Subject: FW: COMMENTS TO PLANNING CONSULTATIONS FROM WILPSHIRE PARISH

3/2021/0213 The application is for regularisation and alteration of unauthorised paved patio area on multiple levels to the front of the house at 18 Bryers Croft Wilpshire

WPC - Wilpshire Parish Council objects to these proposals on the following grounds:-

320210213P

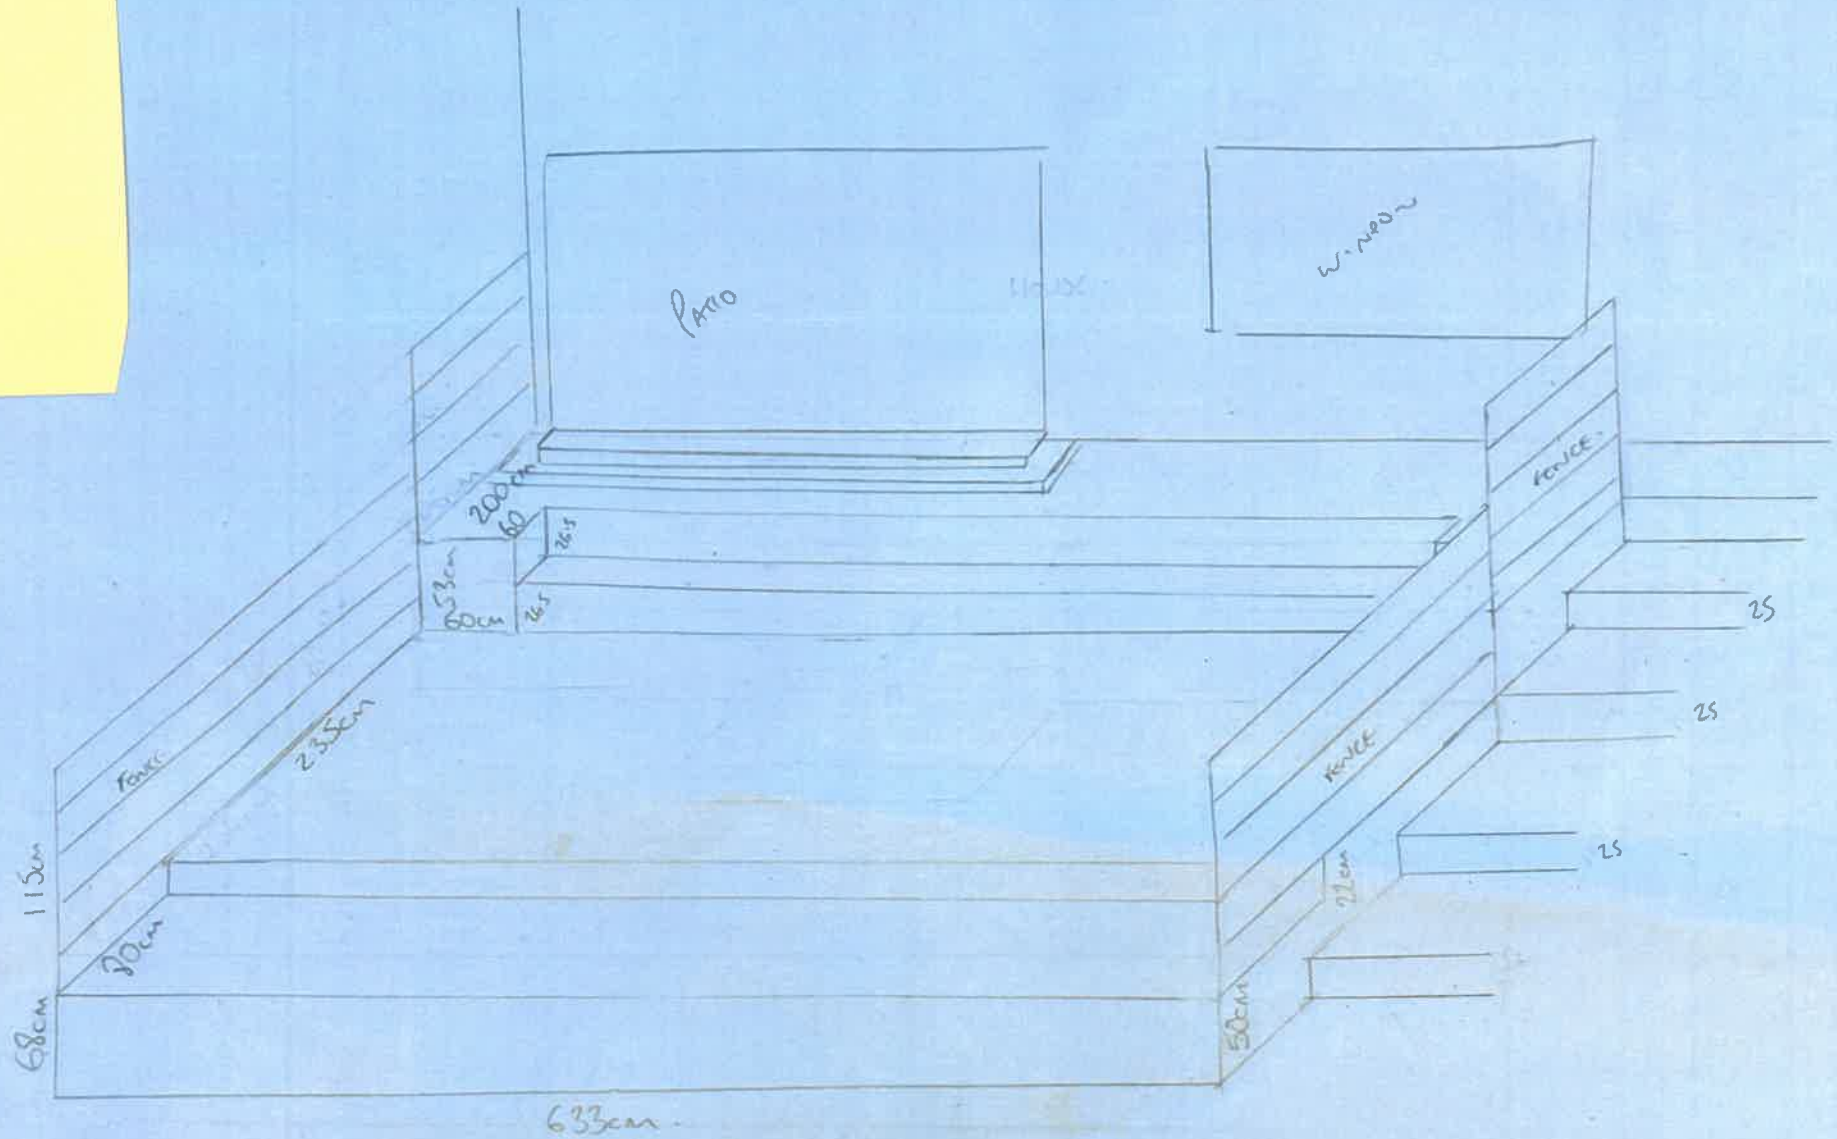
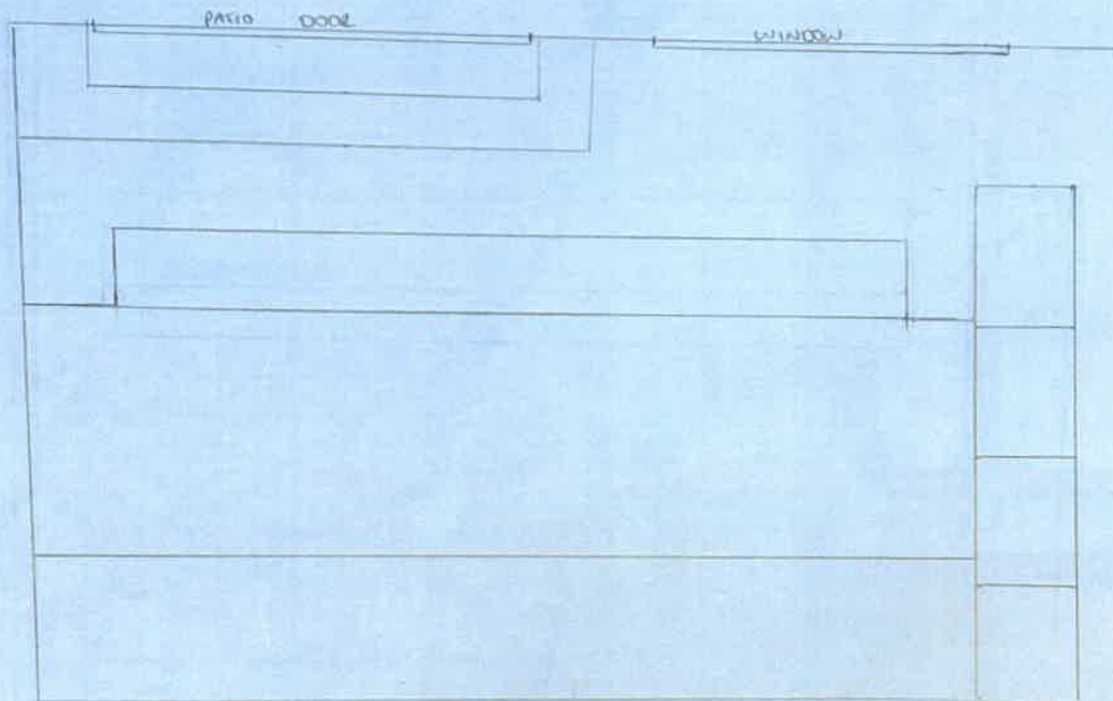
- 1. An elevated patio to the front of the property is out of character in the area and will have an adverse affect on the street scene.
- 2. The proposed development will have an adverse affect on residential amenity in the following ways:
 - i) the introduction of a patio door (the approved plan 3/2019/0707 showed retention of an ordinary window) adjacent to an upper storey window of the neighbouring house will create privacy issues and noise nuisance.
 - ii) an elevated patio to the front (west facing) will create noise nuisance to all properties on Bryers Croft and create privacy issues for the adjoining house especially given the unusual design of this pair of properties.

In addition the Council draws attention to the fact that water runoff on to pavements is a problem in this area and requests that the drainage be addressed should permission be granted for a patio area.
